From: David Easton
Sent: 20 December 2017 09:19
To: Karen Parsons
Subject: FW: A/155/17/OUT - Avenals Barn, Angmering
Attachments: Proposed dwellings - Plan Elevations.pdf; Proposed dwellings - Site plans.pdf

Subject: A/155/17/OUT - Avenais Barn, Angmering

Date: July 2017 Scales: As shown Paper size: A1 Dwg No: AR-122-01-A

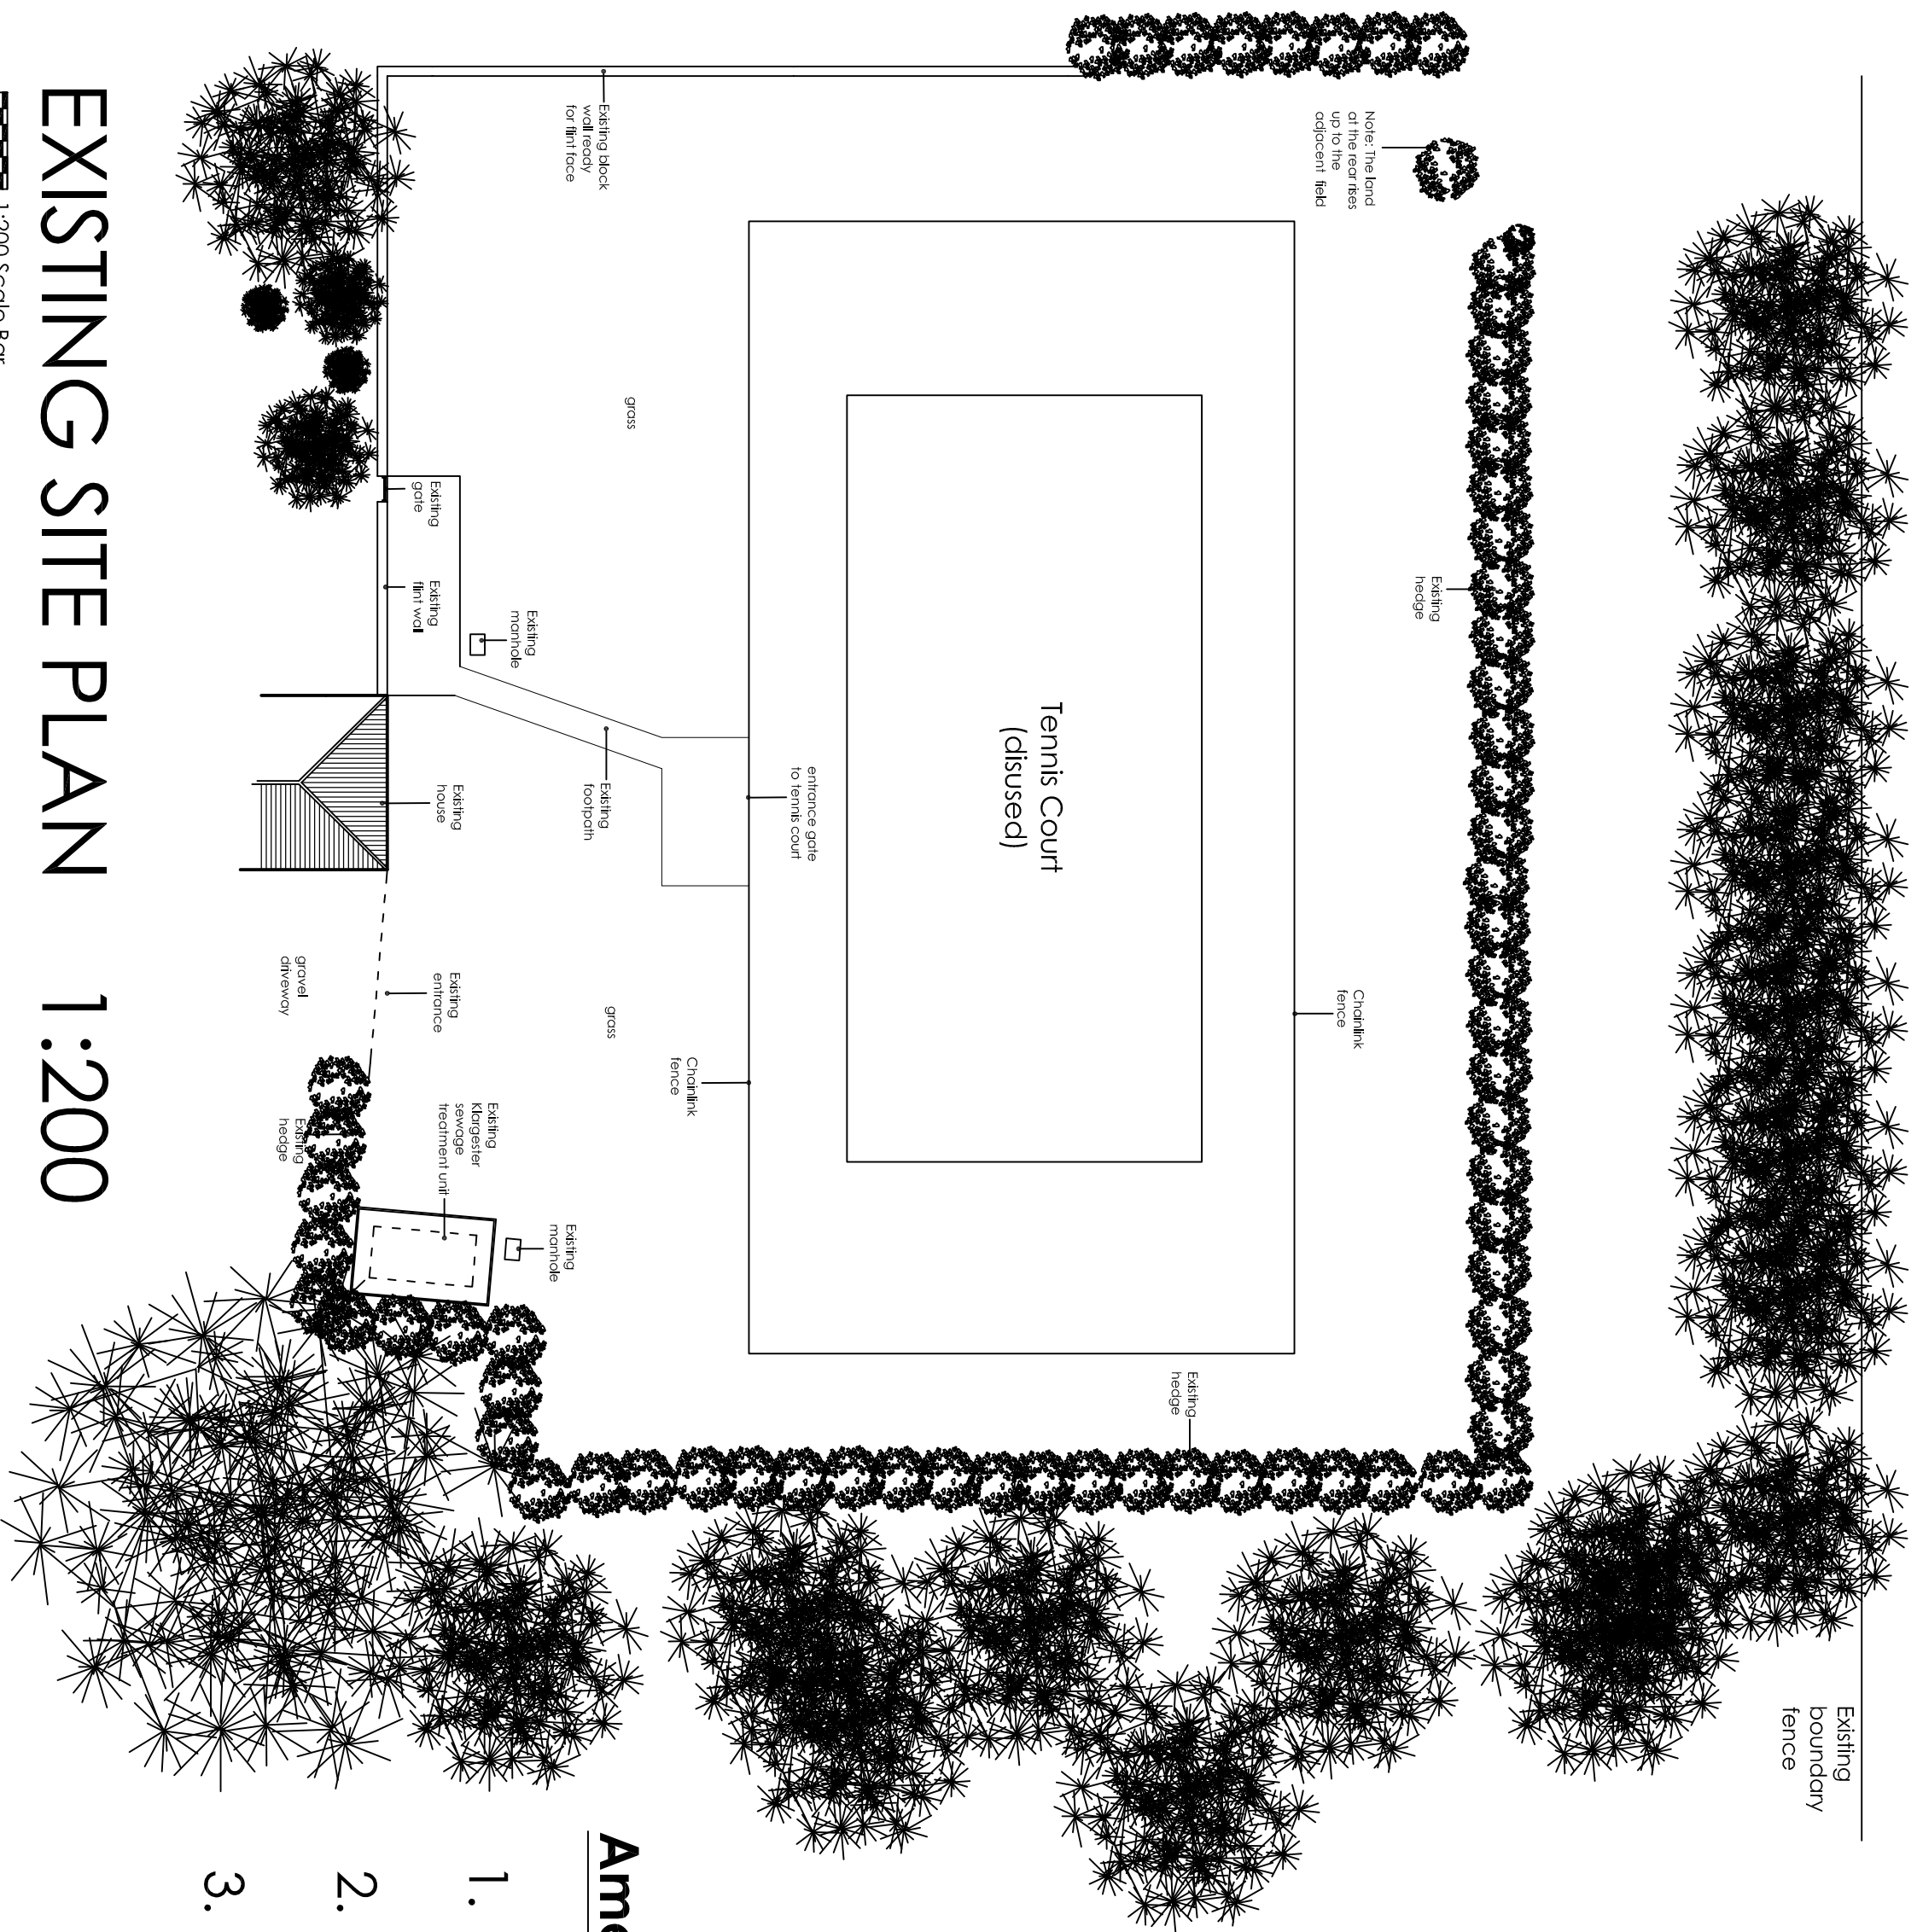
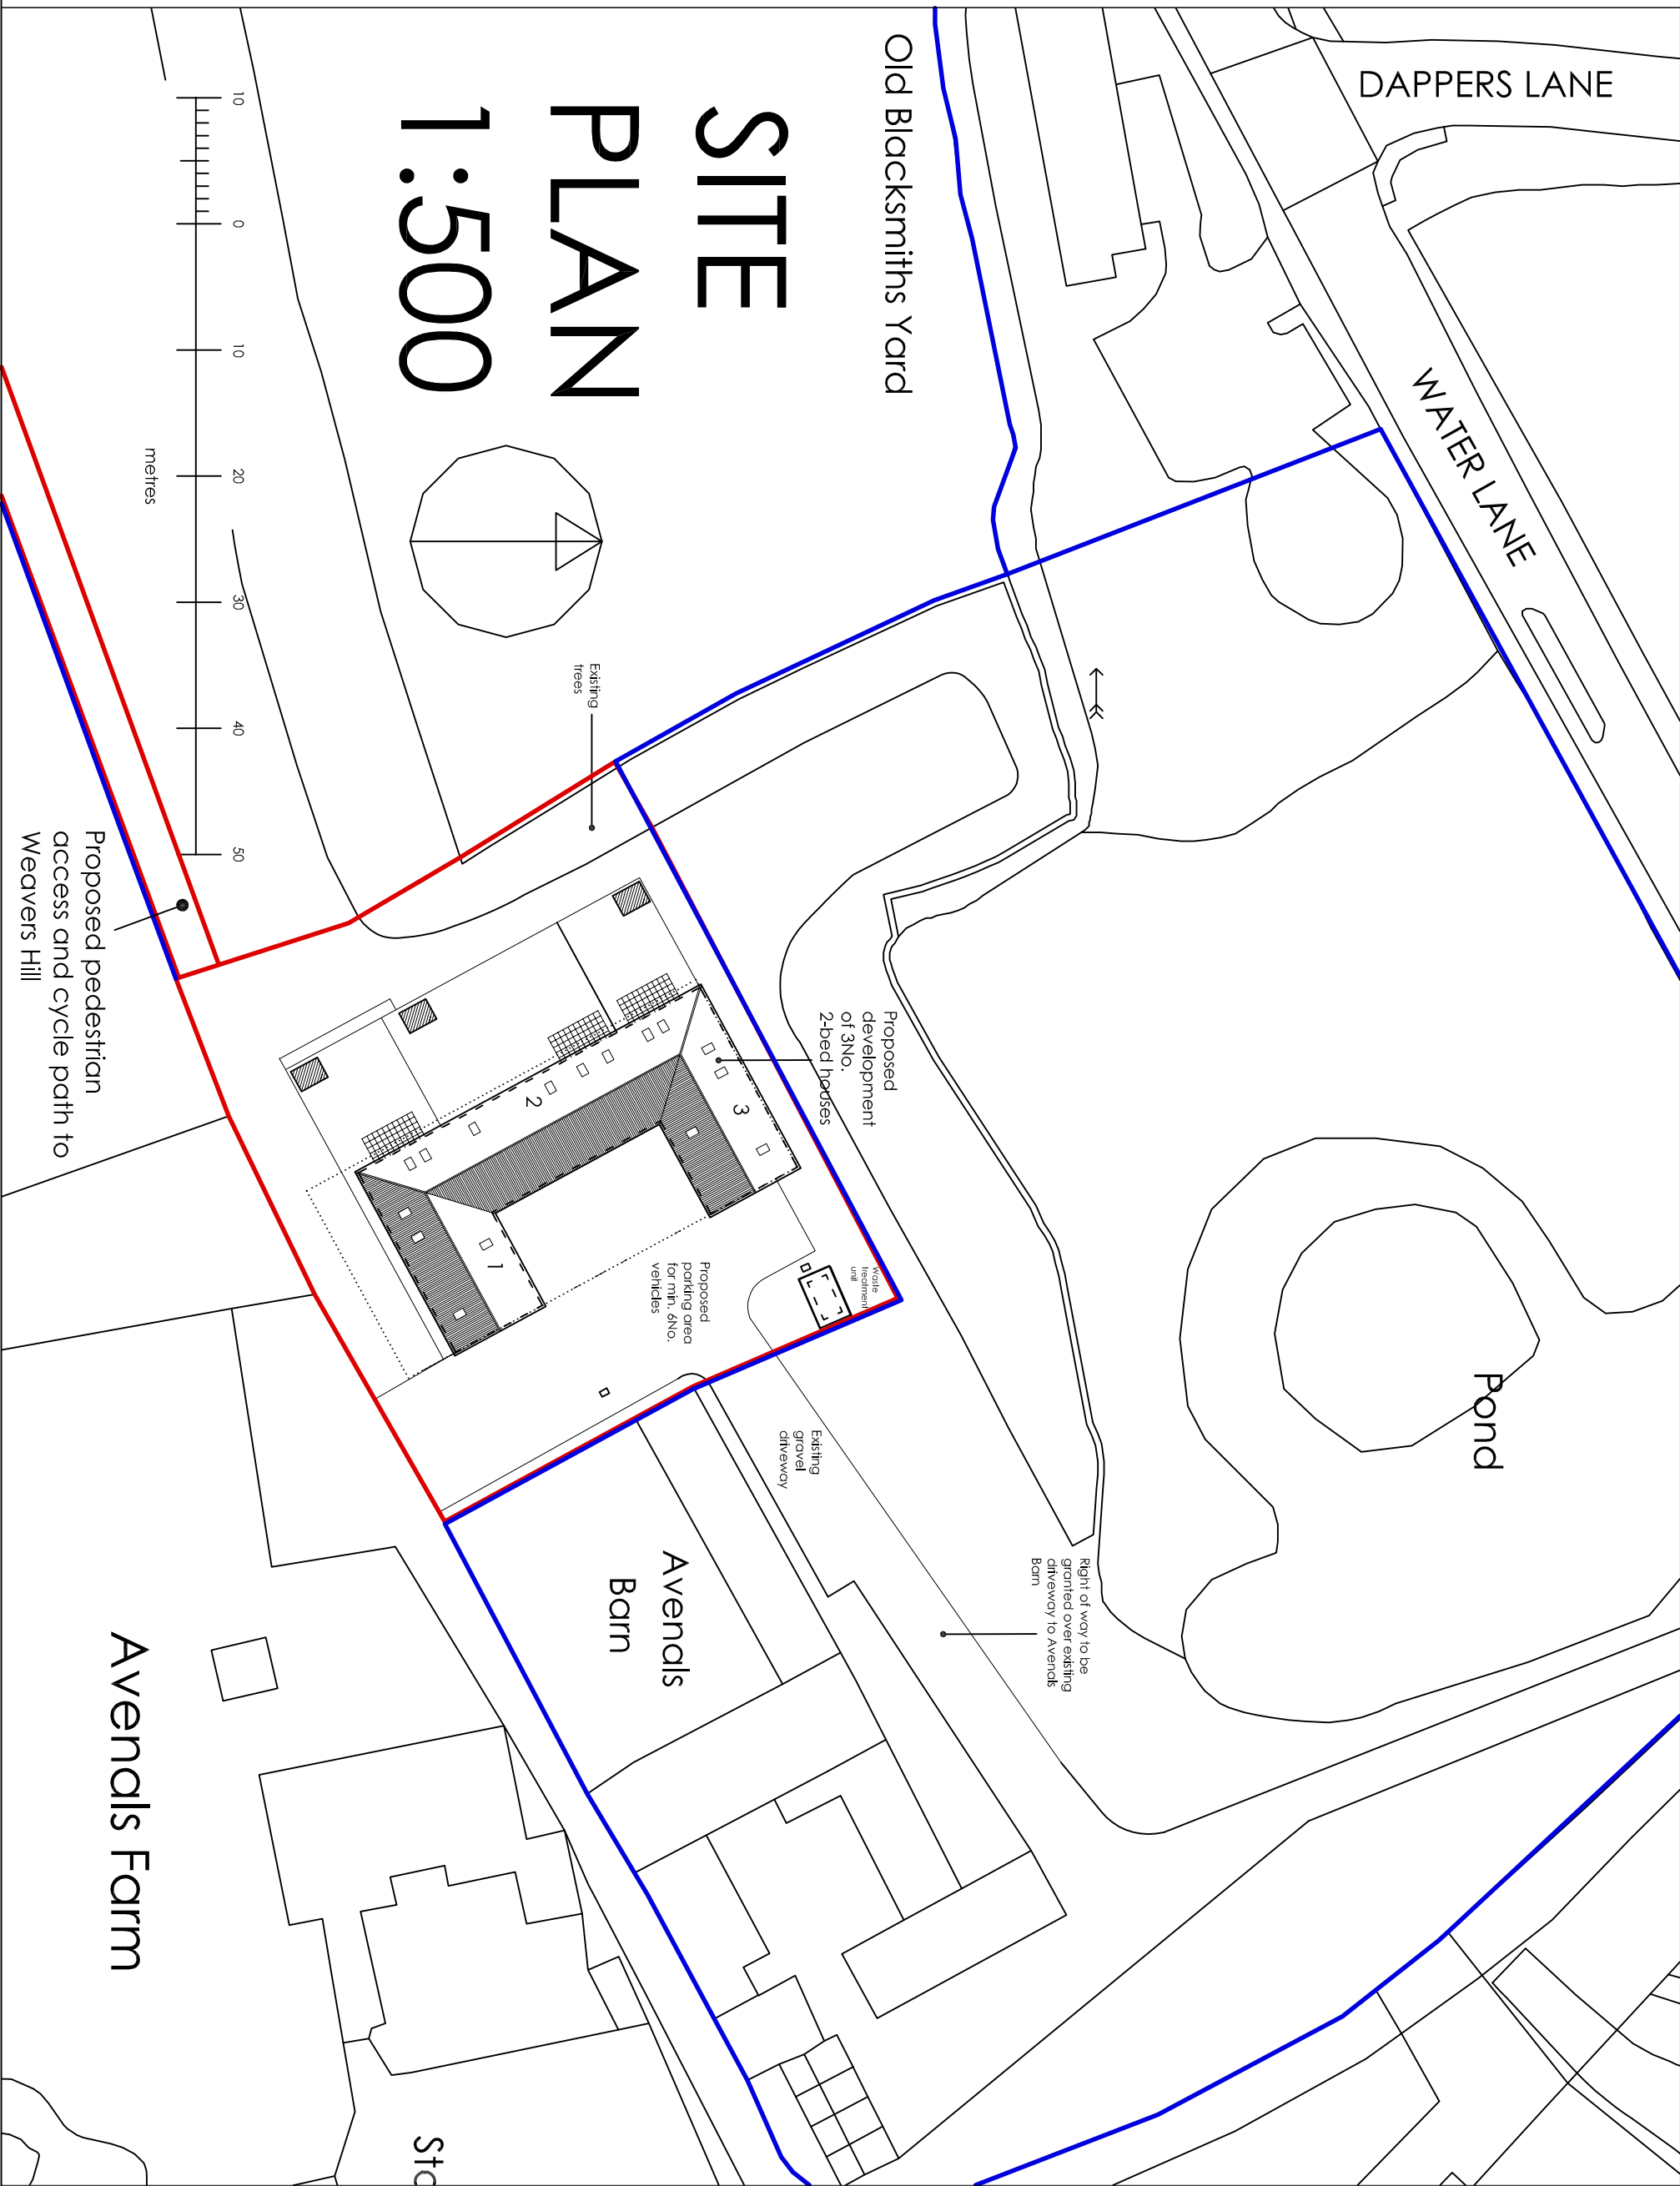
As discussed the major concern held by the Council at this time relates to the severance of the site due to the absence of a pedestrian footway along Water Lane. Therefore, despite the distances being considered acceptable the absence of this pedestrian link prevents the site from being considered sustainable. However, following our discussions you have advised that the applicant in this case owns the land to the west of the application site and as such the red edge could be extended to Weaver's Hill to provide a pedestrian link into Angmering. Therefore, I would advise that an location plan is submitted to allow the LPA to secure this pedestrian link.

I have also advised that some concerns exist in relation to the garden sizes of Plot 1 and 3 and as such recommend that some consideration is given to how best to meet the requirements of policy D DM3 of the emerging Local Plan.
